Objection to the East Pye Solar Development Consent Order

Personal impact on our home, our family and Footpath 6, Brooke (Site 9)

Project	East Pye Solar (Planning Inspectorate reference EN0110014)
Applicant	East Pye Solar Limited (Island Green Power)
Submitted jointly by	Michael Phillips and Helen Phillips
Address	[REDACTED]
Interested Party reference	[REDACTED]
Submission	Joint Written Representation for the Examination deadline of 6 October 2026
Date	5 October 2026

FIGURE 10.4
TRAFFIC SURVEY LOCATIONS

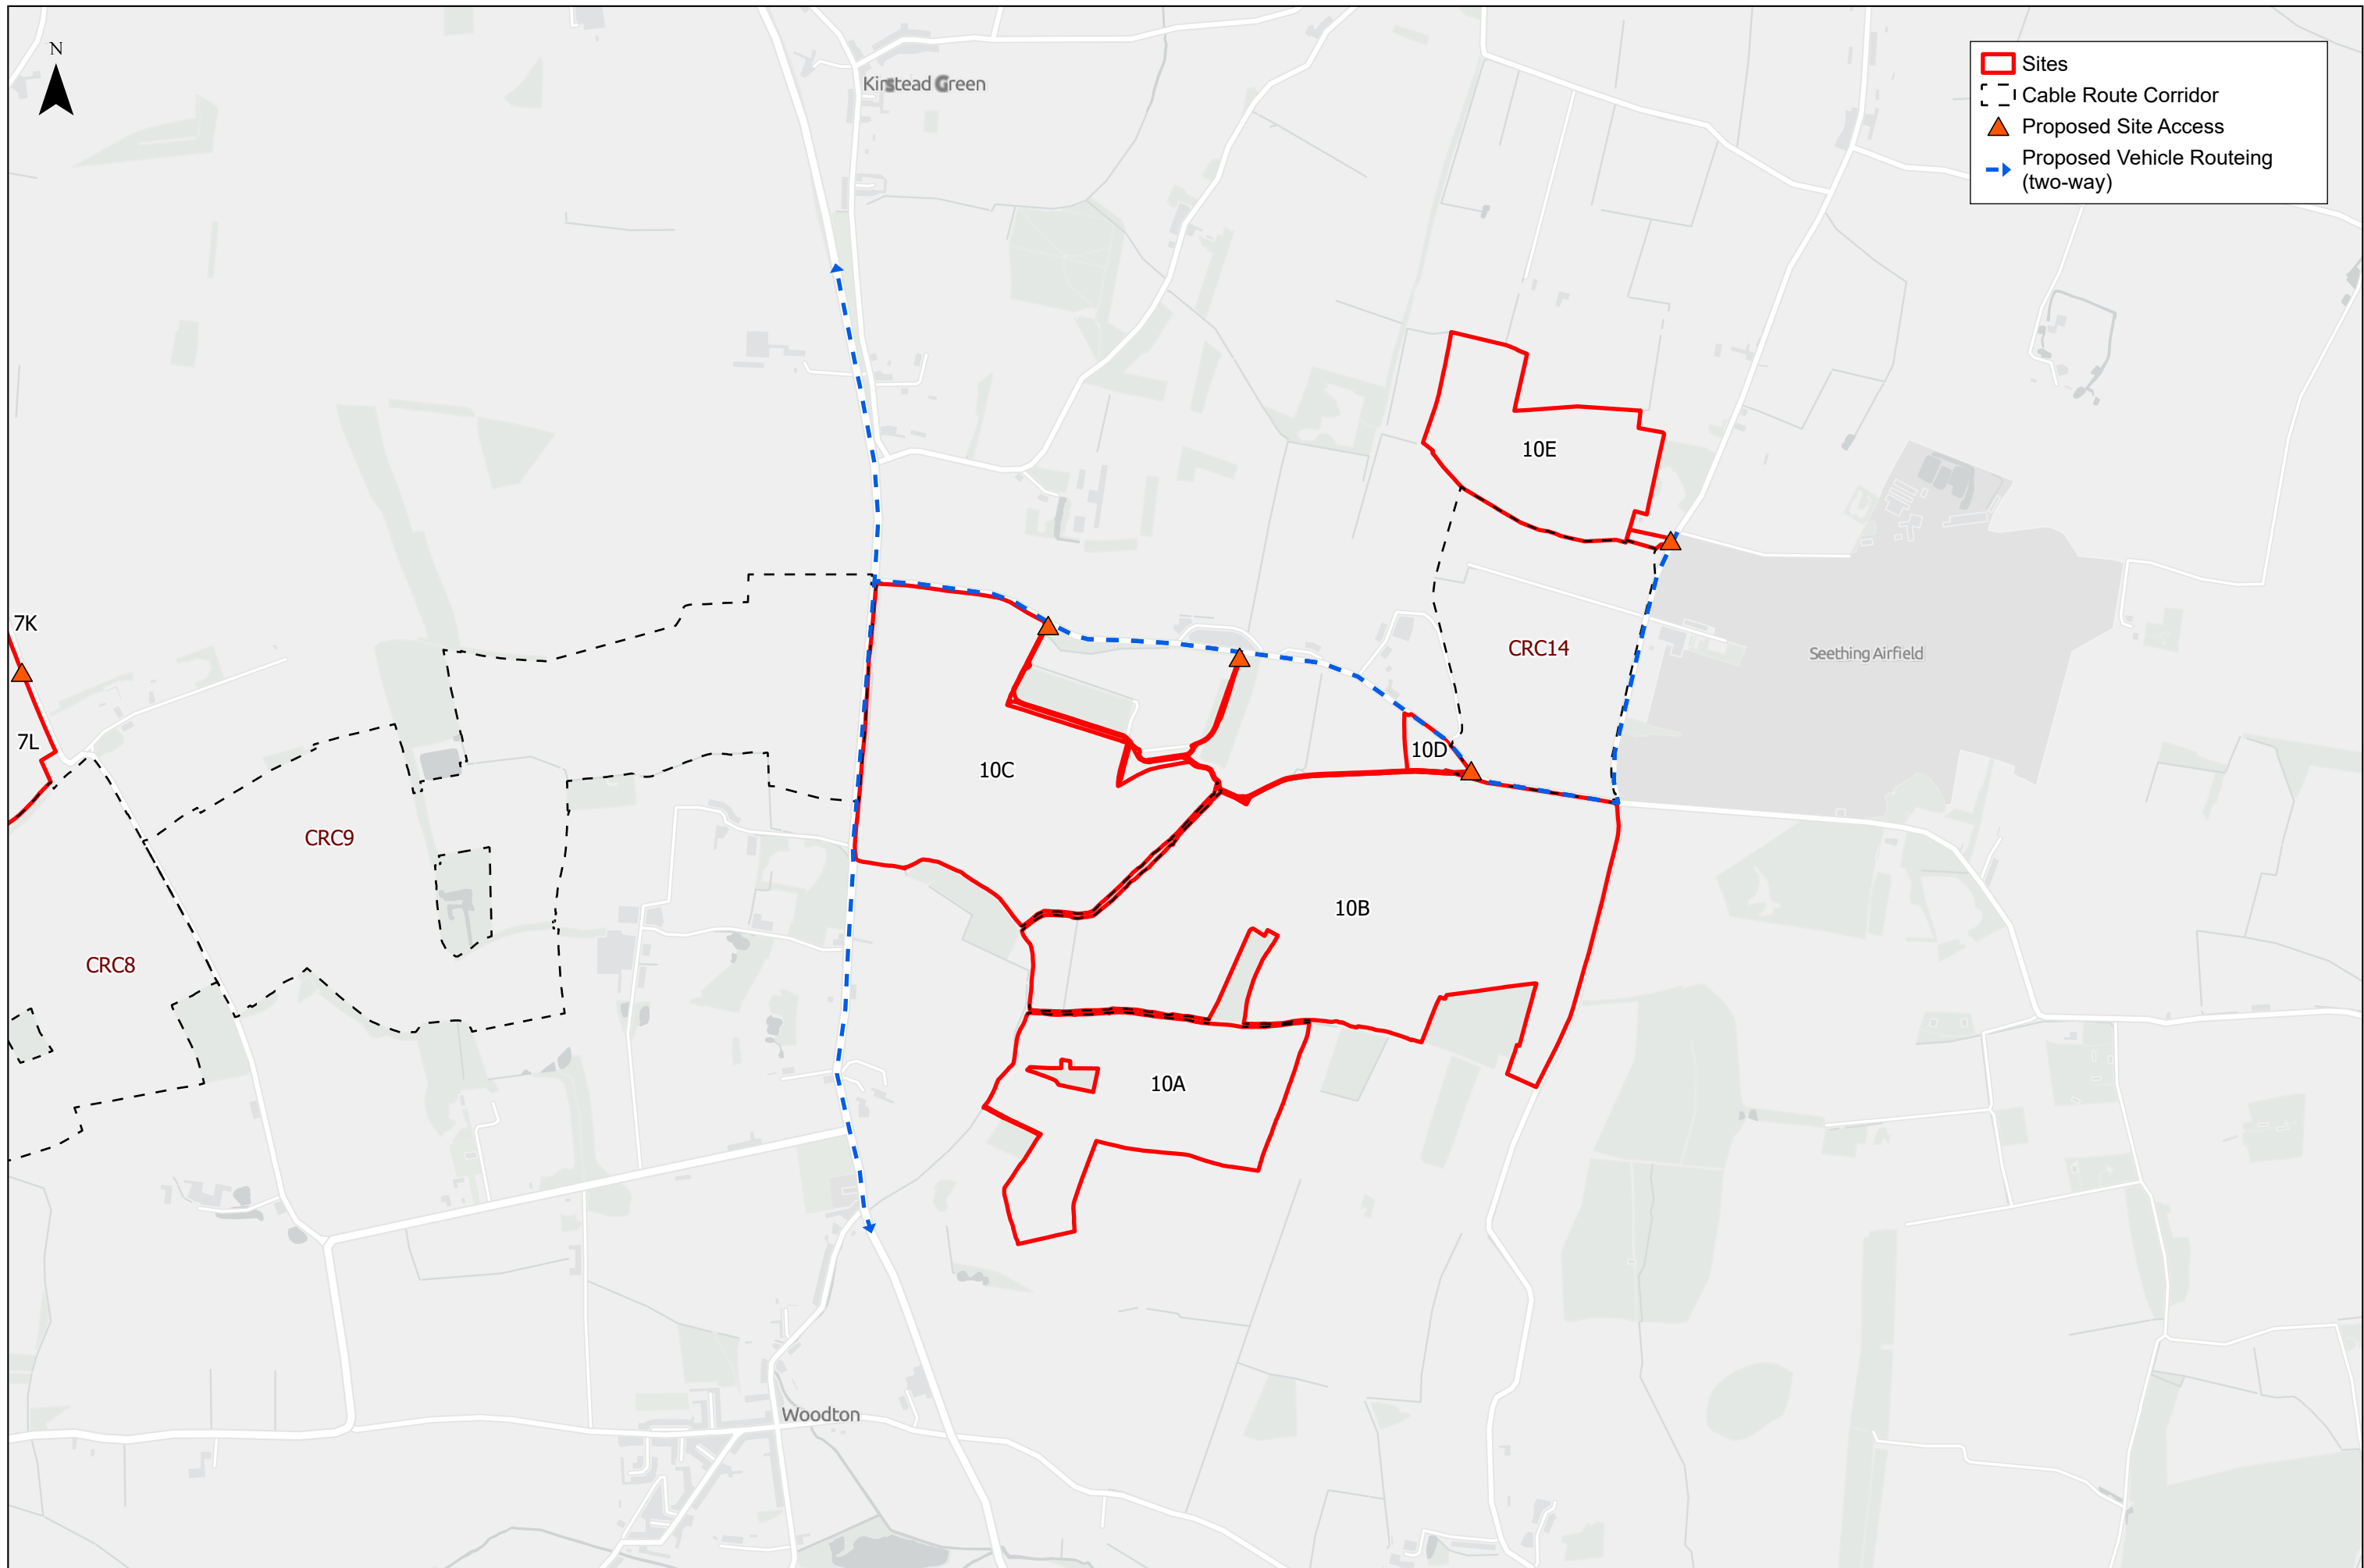
Despite this, the applicant identifies Littlebeck Lane as an access route for Site 9. Option A in the Scoping Report is "From B1332 Norwich Road, westbound on Littlebeck Lane, north onto access point on Site 9" (Table 10.4). The applicant's published figures show:

Figure 11.6: Likely and Suitable Routes to the Scheme
 Sites 7, 8 and 9
 Revision A

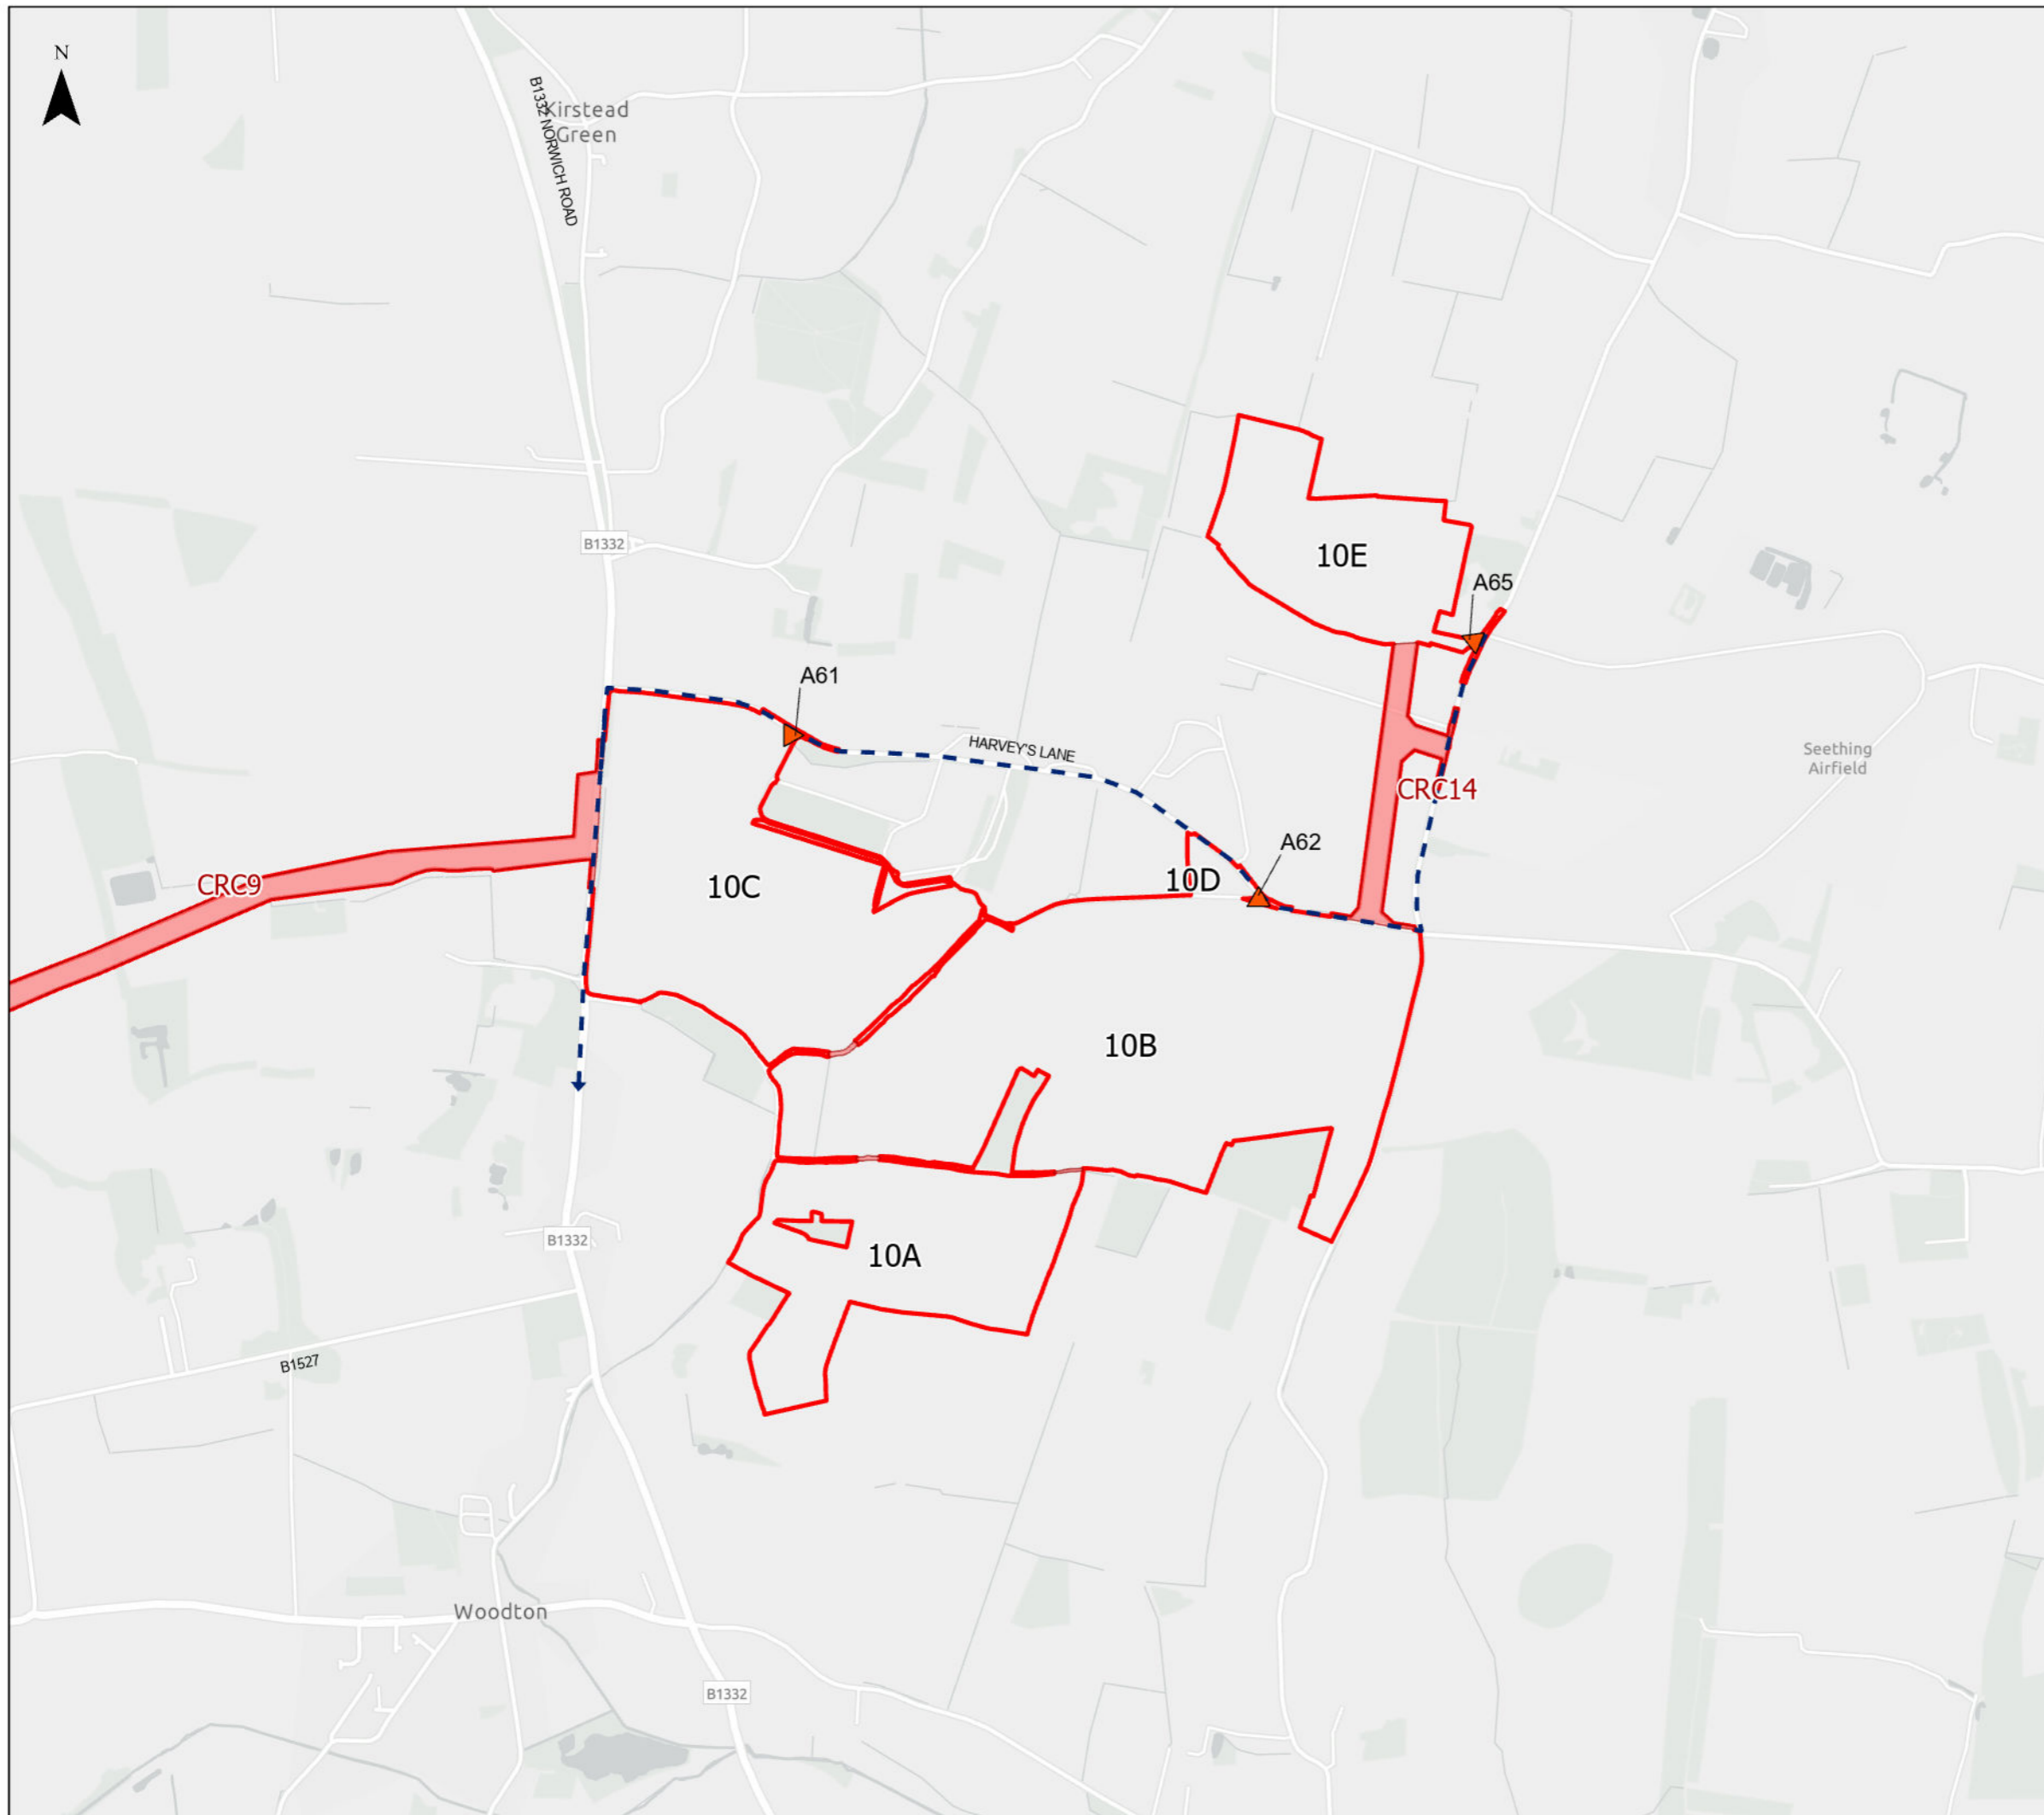
- Mill Lane and Littlebeck Lane are single-track lanes with passing places. They are not suitable for construction traffic, yet the applicant names Littlebeck Lane as an access route to Site 9.

HGVs on a single-track lane mean vehicles reversing to passing places, verges and ditches being damaged, and real danger to anyone on foot. This is the lane that Footpath 6 joins and that we, our dogs and our grandchildren use every day. Residents have also told Brooke Parish Council that the roads around Site 9 are narrow, single-track and already used as "rat runs". The Inspectorate has said that road-traffic vibration cannot be scoped out without evidence on road condition, vehicle routes and site access (para 3.18.3). We do not believe the applicant has shown that this route can be used safely.
